City of Portland, Maine - Building or Use Permit Application
 389 Congress Street, 04101 Tel: (207) 874-8703, Fax: (207) 874-8716

Permit No: 04-1326	Issue Date:	CBL: 330 D005001
------------------------------	--------------------	----------------------------

Location of Construction: 153 Tucker Ave	Owner Name: W & C Llc	Owner Address: Po Box 10127	Phone:
Business Name:	Contractor Name: Teal LLC	Contractor Address: 286 Falmouth Road Falmouth	Phone 2077813224
Lessee/Buyer's Name	Phone:	Permit Type: Single Family	Zone:

Past Use: Vacant Land	Proposed Use: Vacant Land / Build 24' x 48' SFH w/ 2 car garage	Permit Fee: \$906.00	Cost of Work: \$90,000.00	CEO District: 5
Proposed Project Description: Build 24' x 48' SFH w/ 2 car garage		FIRE DEPT: <input type="checkbox"/> Approved <input type="checkbox"/> Denied	INSPECTION: Use Group: Type	
		Signature:	Signature:	
PEDESTRIAN ACTIVITIES DISTRICT (P.A.D.)				
Action: <input type="checkbox"/> Approved <input type="checkbox"/> Approved w/Condition <input type="checkbox"/> Denied				
		Signature:	Date:

Figure No. **1**

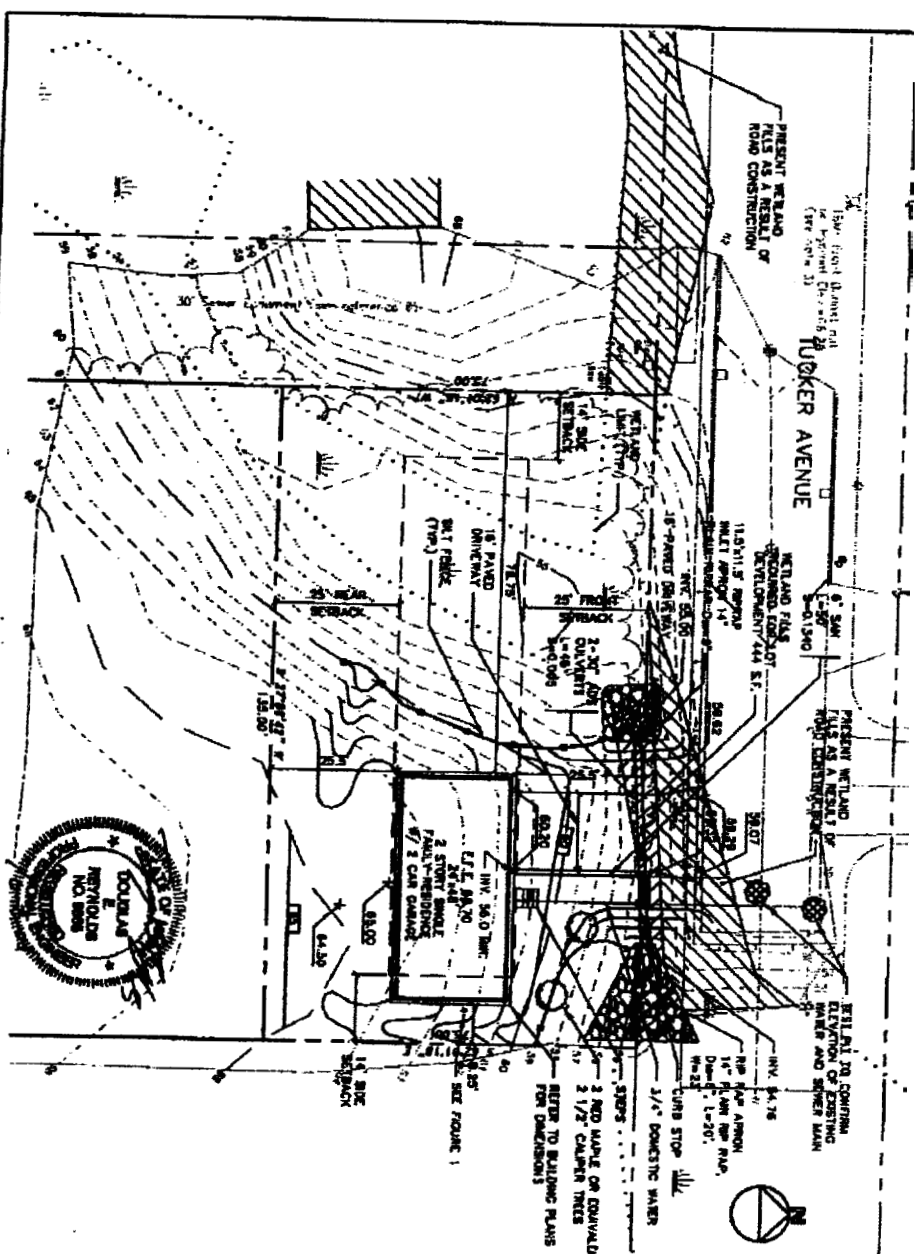
Note: 9/9/04 I need to see a copy of the recorded appeal variance that was granted - also question on the side setback - I need to see what was approved previously (It appears that I erred on the setback reduction)- I left a message with Bob Adam - The setback must be corrected at this time. **Ok to Issue:**
9/15/04 received a copy of the recorded variance and revised plans showing a 12.25' side yard setback

LOWER LEVEL PLAN

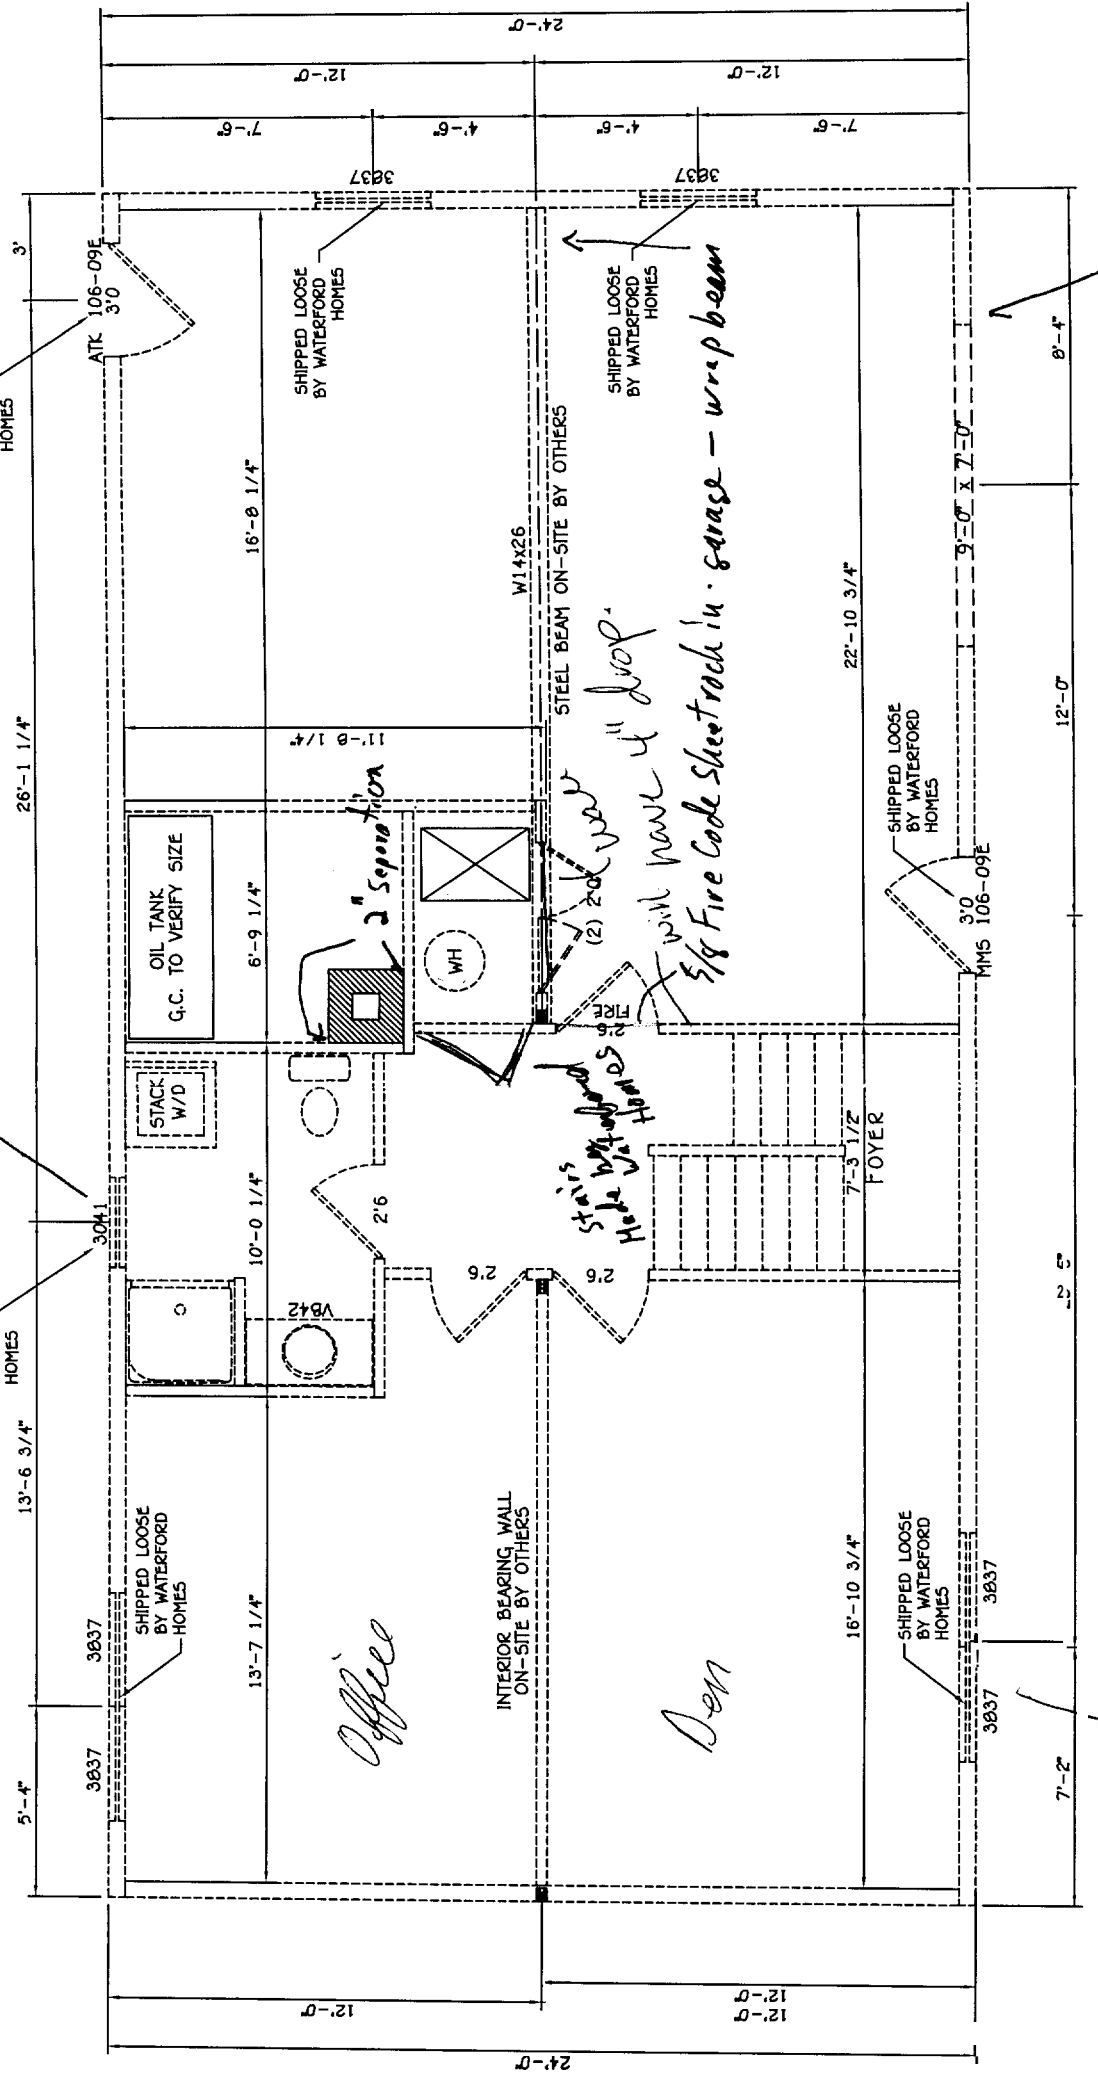
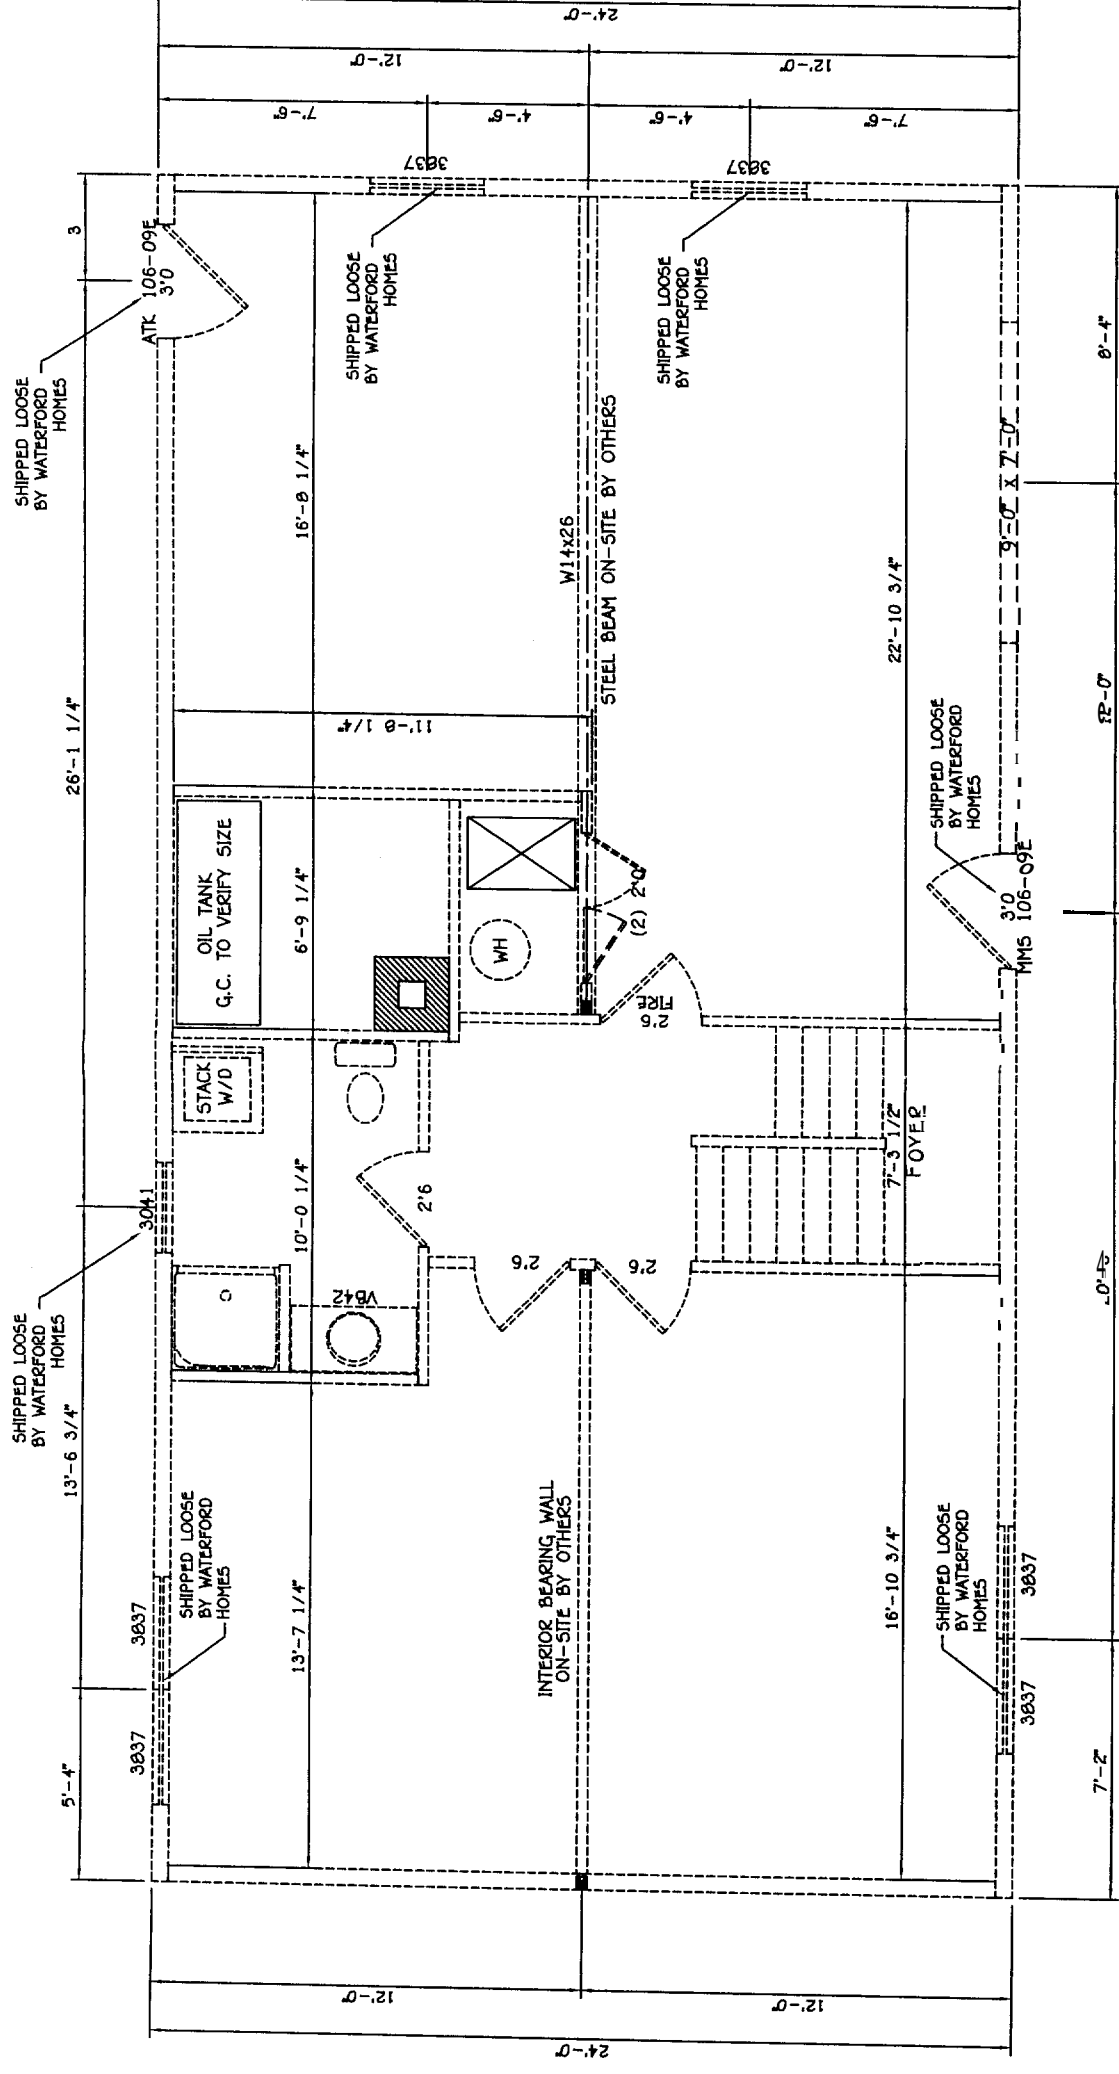
9/28/04-tmm: need correct floor plan - the current on shows lally columns in the middle of garage, need basement plan and framing details of porches. Called owner/builder.

9/29/04-tmm: rec'd additional info - still need stair detail.
